Phone: 0300 123 6780  
Email: lhscustomerservice@lancashire.gov.uk  
Your ref:  
Our ref: LHS/CS/3/2017/0208 & 0209  
Date: 30<sup>th</sup> March 2017

<b>Proposal:</b>	Conversion from one dwelling into two including single storey extensions to rear.
<b>Location:</b>	11-13 Gisburn Road Bolton by Bowland BB7 4NP
<b>Grid Ref:</b>	378701 - 449377

proposed rear elevation

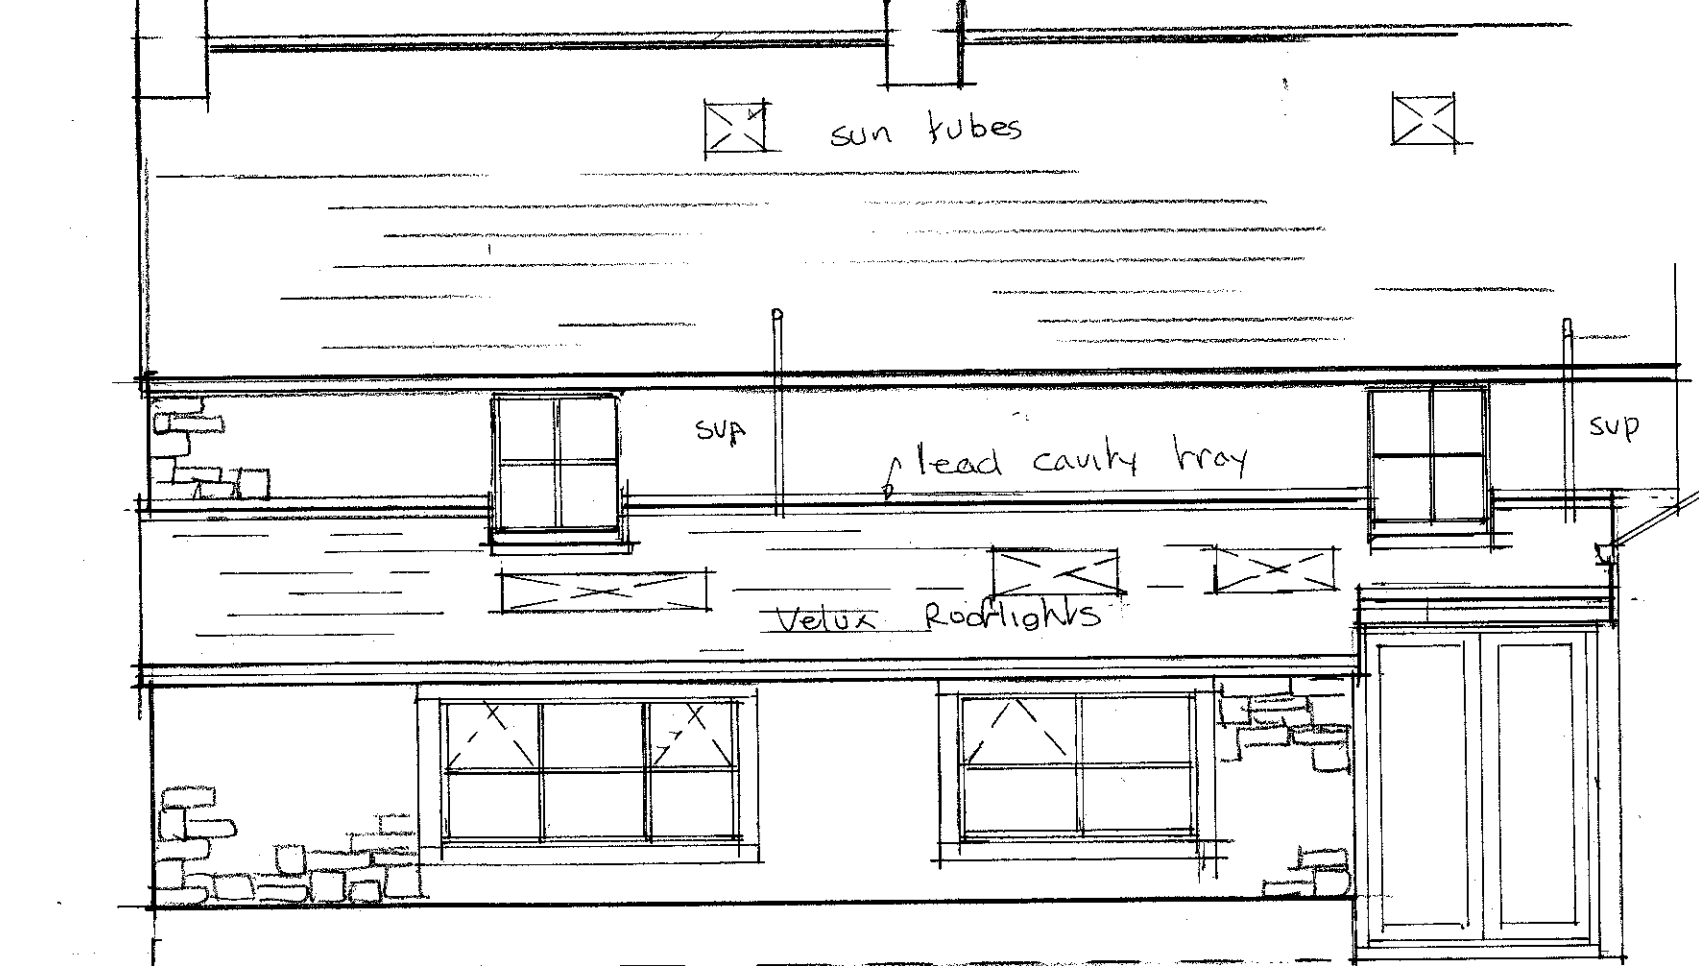
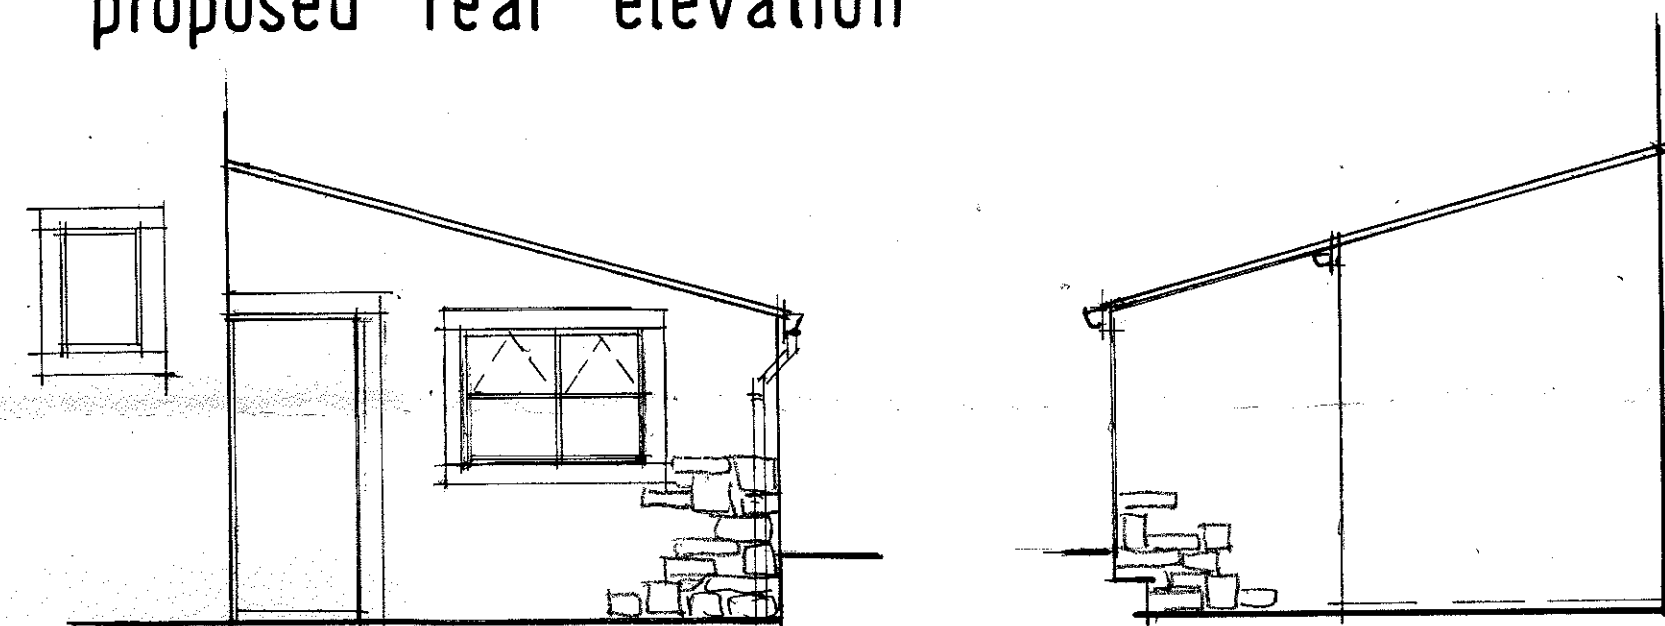
1. Prior to the start of the development, a joint survey shall be carried out between the developer and the planning authority (in conjunction with the highway authority) to determine the condition of the back street. A similar survey shall be carried out within one month of the external works of the extension, and the developer shall make good any damage to back street to return it to the pre-construction situation. Reason; To maintain the construction of back street in the interest of highway safety.
2. Surface water from the development must not discharge onto the back street. Reason; To prevent private water discharging in to the highway drainage system.
3. The maximum overhang of the gutter to be 200mm. Reason to ensure the carriageway width for vehicles is not restricted.
